Our Ref: AE/HMH/R00525
LPA Planning Ref: 49467/APP/2022/2801

Shurgard House, Uxbridge Road, UB4 0HD

DETAILS PURSUANT TO FULL PLANNING APPLICATION
LPA APPLICATION REFERENCE 49467/APP/2022/2801.

DRAWING NO.
21065GA-D-003

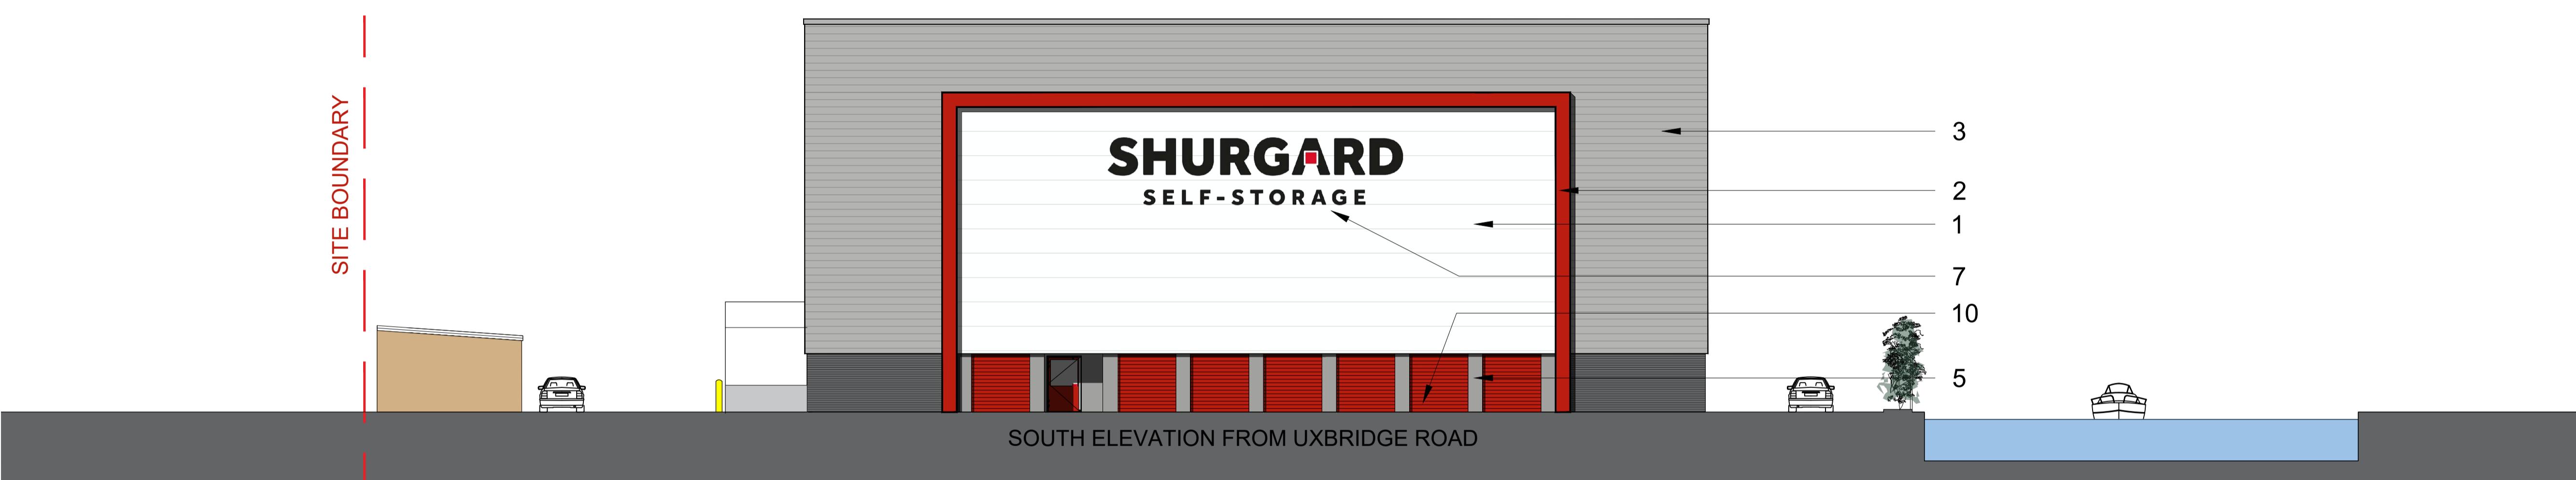
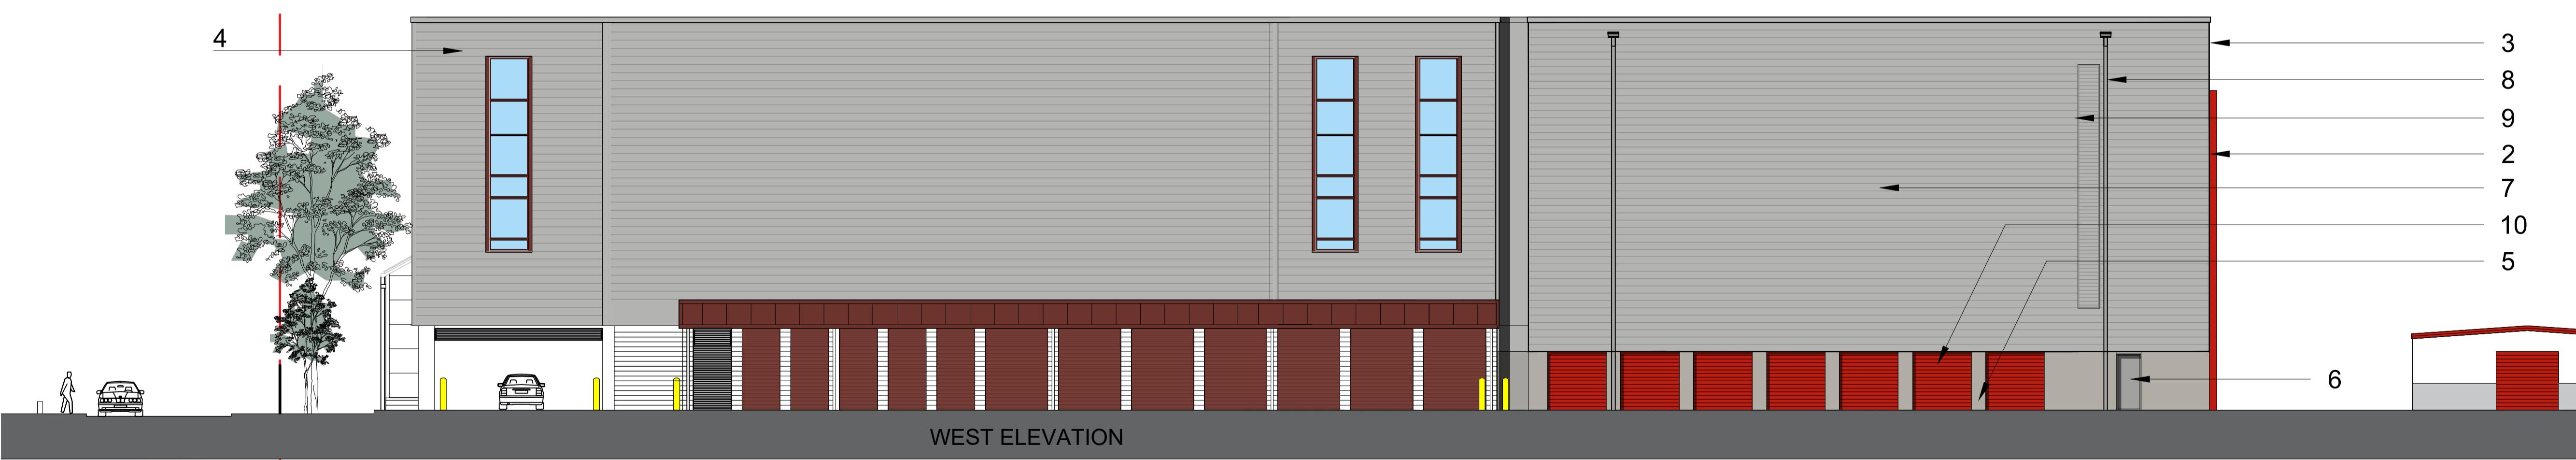
Plans 21065GA-D-003A *Elevations Planning* and 21065GA-D-004B *Section* confirm that the pastiche gables are to be removed as part of the proposed development and the height of the building to the top of the parapet is 63.050m A.O.D.
